Re: PA23-008, Krykun Duplex, *Technical Review 3*

<b>File Number:</b>	PA23-008
<b>Project Title:</b>	Krykun Duplex CUP
<b>Project Description:</b>	2-story duplex in the R4.5 zone. Subject property contains steep slopes, a wetland, and wetland and stream buffers.
<b>Applicant:</b>	Pavel Krykun
<b>Project Location:</b>	10408 Shoultes Rd
<b>APNs:</b>	30051600100800
<b>Application Materials:</b>	<a href="#">Download Application Materials – 3<sup>rd</sup> Submittal Krykun Duplex CUP</a>

COVER SHEET

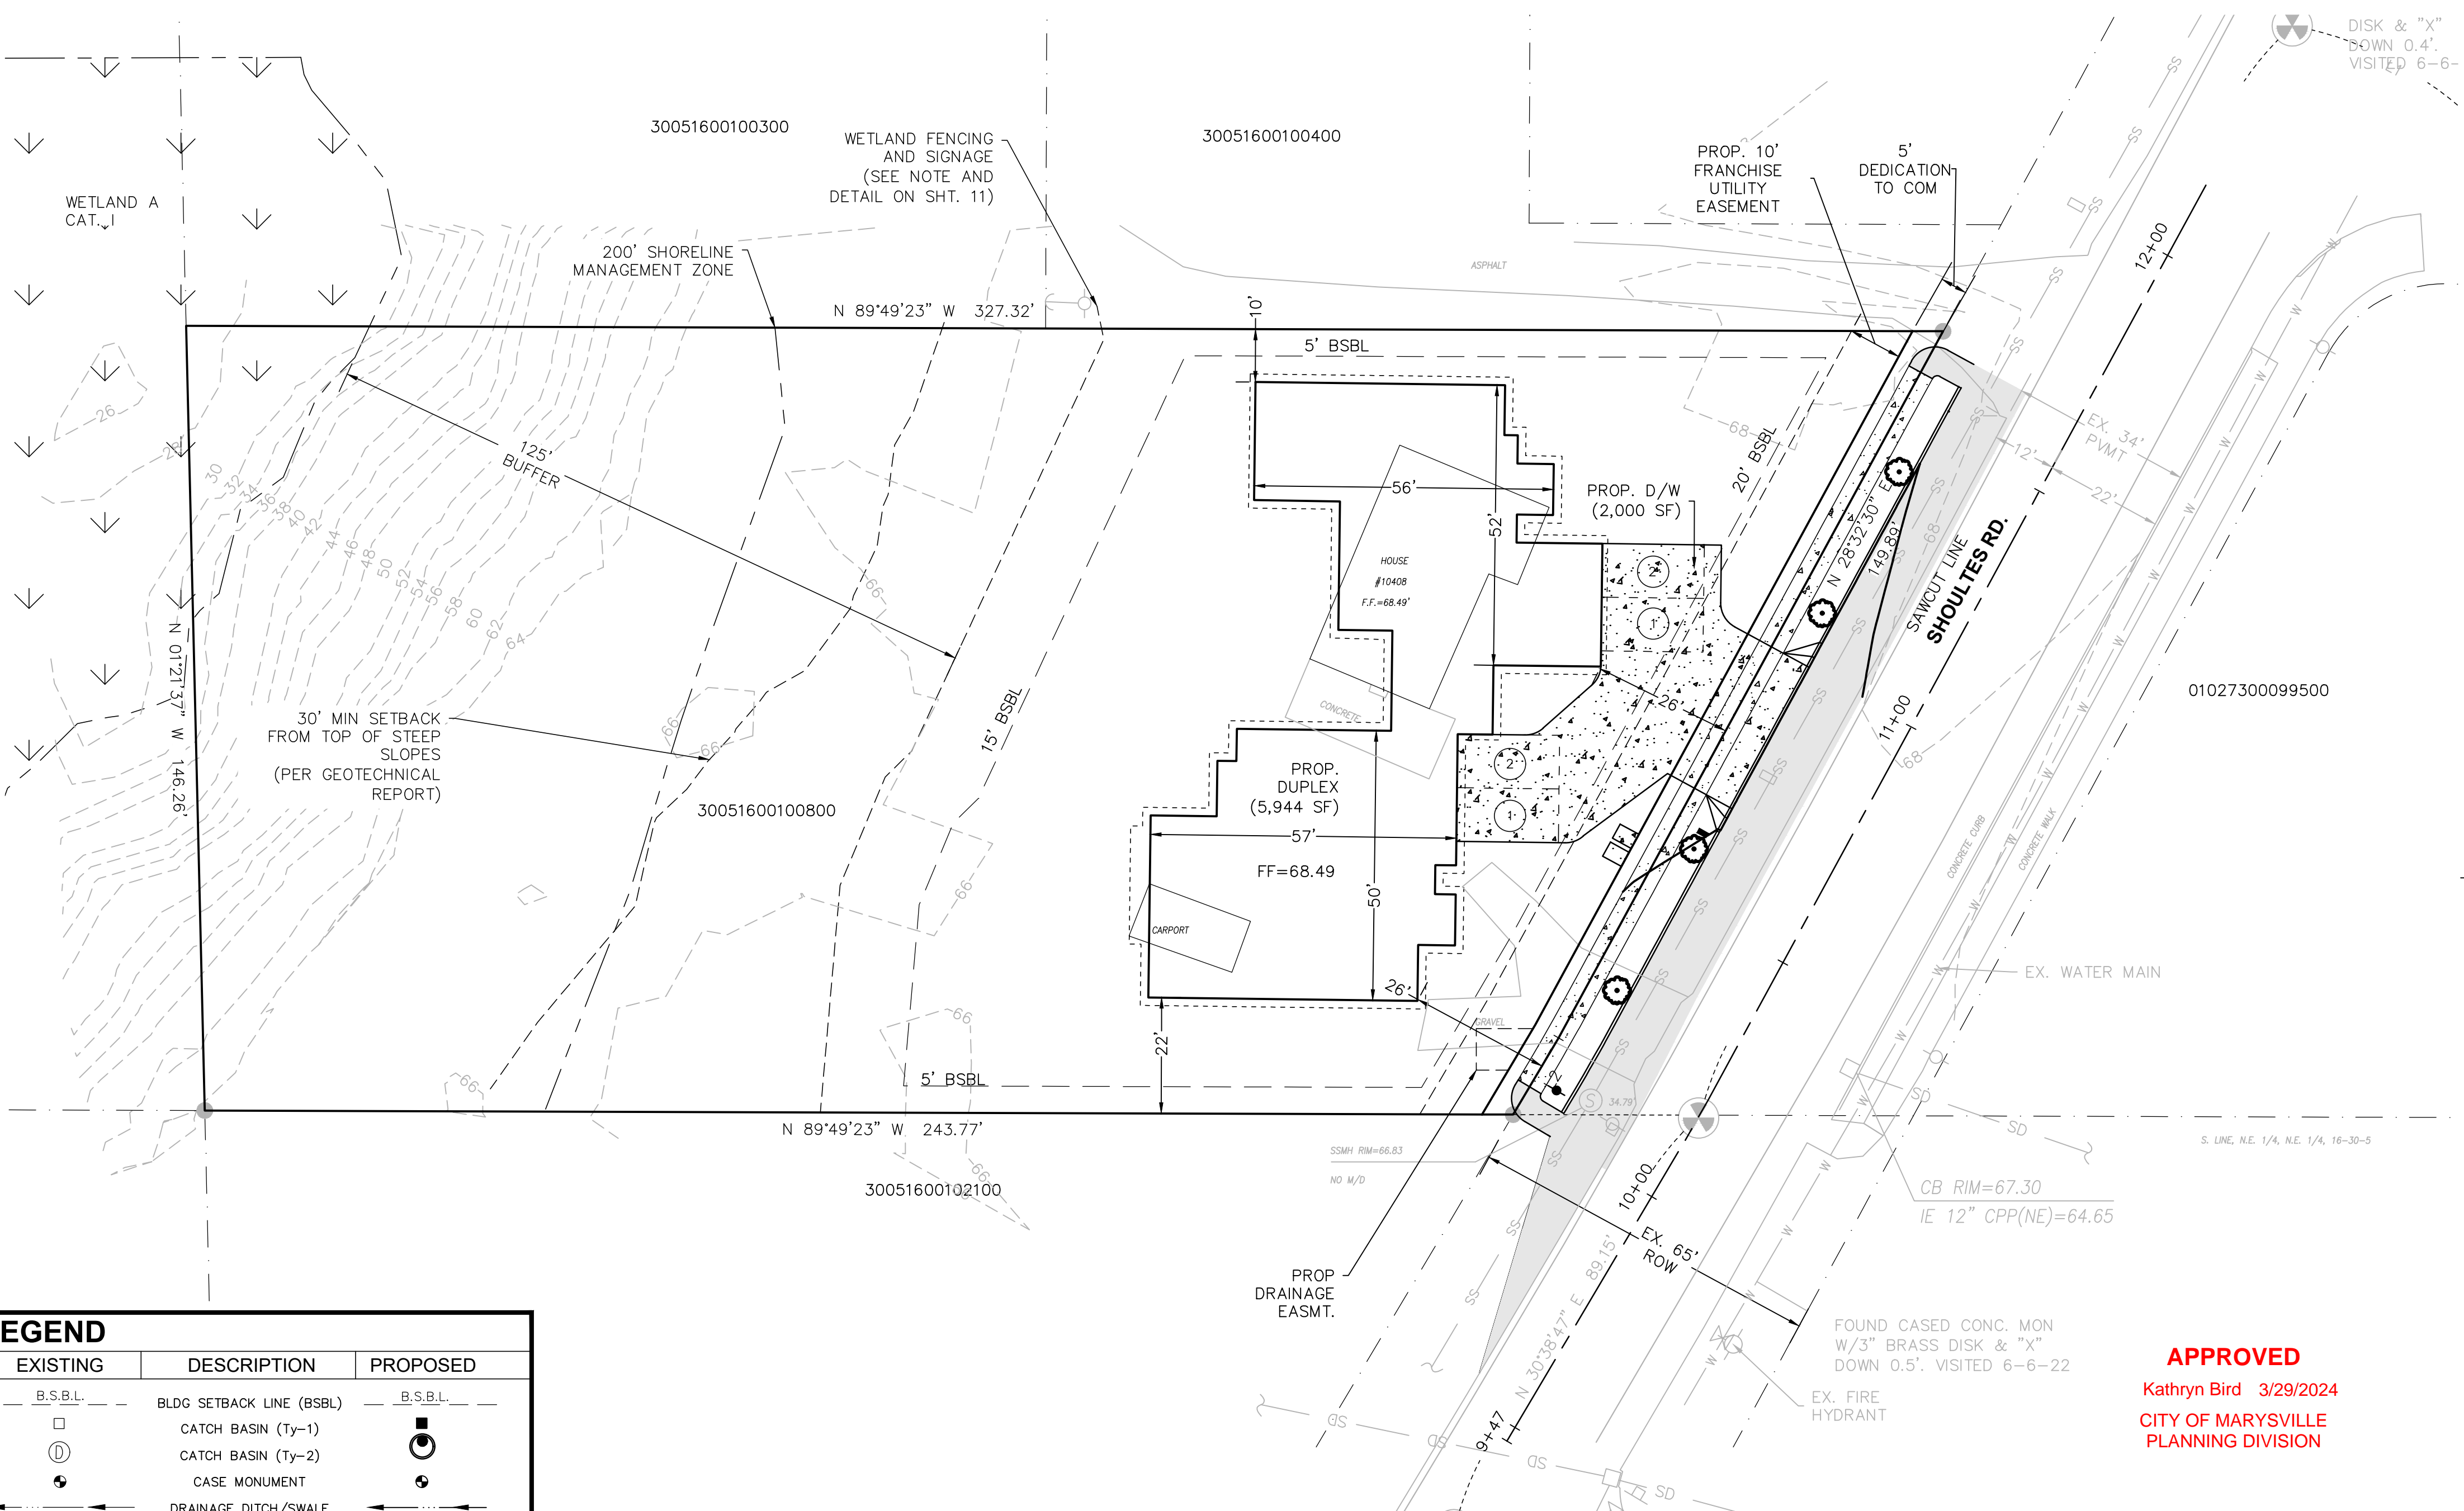
4. On Sheets A01.1 and L1 amend the driveway to match the civil plans.
5. On Sheets 1, 2, 4, and 5 of the Preliminary Civil Plans, show and label the 200-foot shoreline management zone.

6. On Sheet 1 of the Preliminary Civil Plans, provide the percentage of impervious surface proposed.
7. On Sheet 1 of 8 of the Preliminary Civil Plans, provide street trees placed 30 feet on center between the sidewalk and the street. Street trees must be provided as part of the frontage improvements in addition to the landscaping required for duplexes. See [MMC 22C.120.140](#) for details on street tree requirements.
